Current Zoning: R-3 (single family, residential)  
Proposed Zoning: R-8MF(CD) (multi-family residential, conditional)

Approximately 38.18 acres located along the southwest side of Gibbon Road, east of Statesville Road, and south of Old Statesville Road.

The petition proposes to develop a residential community with up to 287 single family attached dwelling units together with accessory uses.

## PLANNING STAFF REVIEW

REZONING PLAN
RZ.01

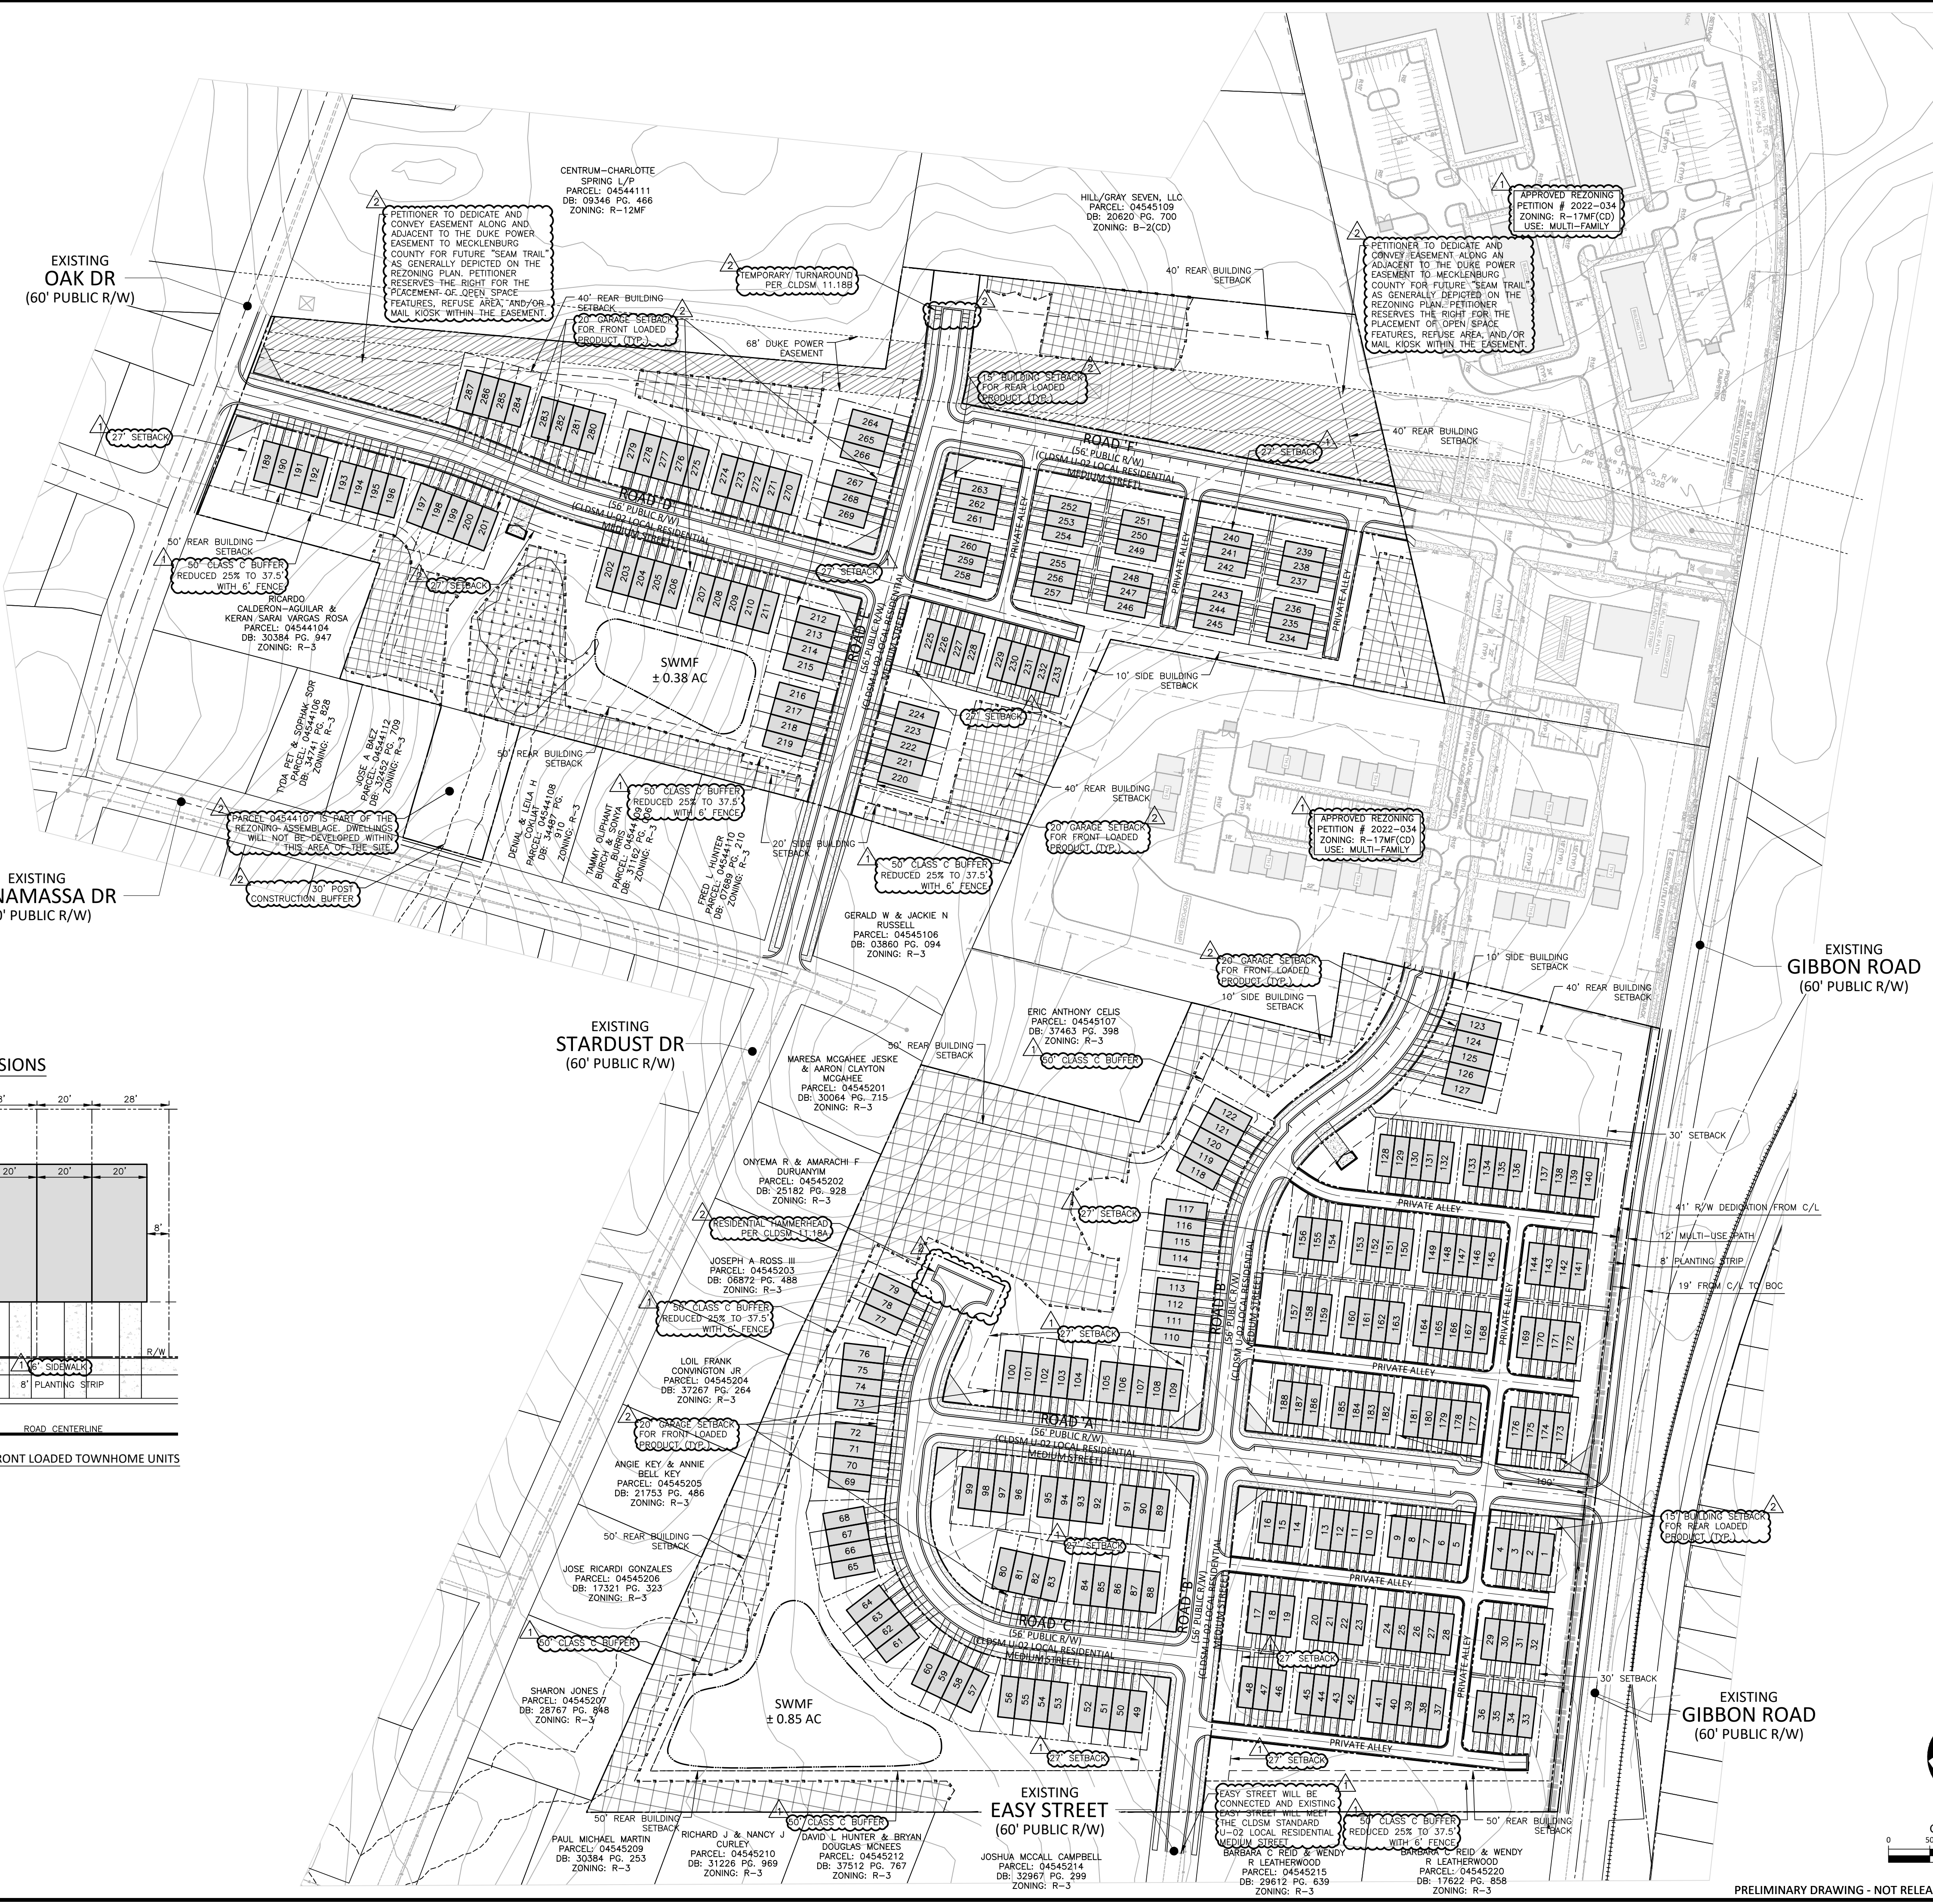
1. Oak Drive: Curb and gutter shall be placed along the entire site's frontage. Label and dimension the proposed curb line from the exiting centerline of the road.

2. Wanamassa Drive: Curb and gutter shall be placed along the entire site's frontage. Label and dimension the proposed curb line from the exiting centerline of the road.

3. Revise conditional note(s) to commit to dedicate 28-feet of right-of-way from the road centerline along Wanamassa Drive in coordination per CLDSM Local Residential Medium Street and 30-feet of right-of-way from the road centerline along Oak Drive in coordination per CLDSM Residential Collector. The site plan shall label and dimension the right-of-way from the road centerline.

4. Revise site plan and conditional note(s) to commit to construct an 8-foot planting strip and 6-foot sidewalk along the site frontages on Oak Drive and Wanamassa Drive. The site plan shall label and dimension both items from the back of curb and gutter and road centerline.
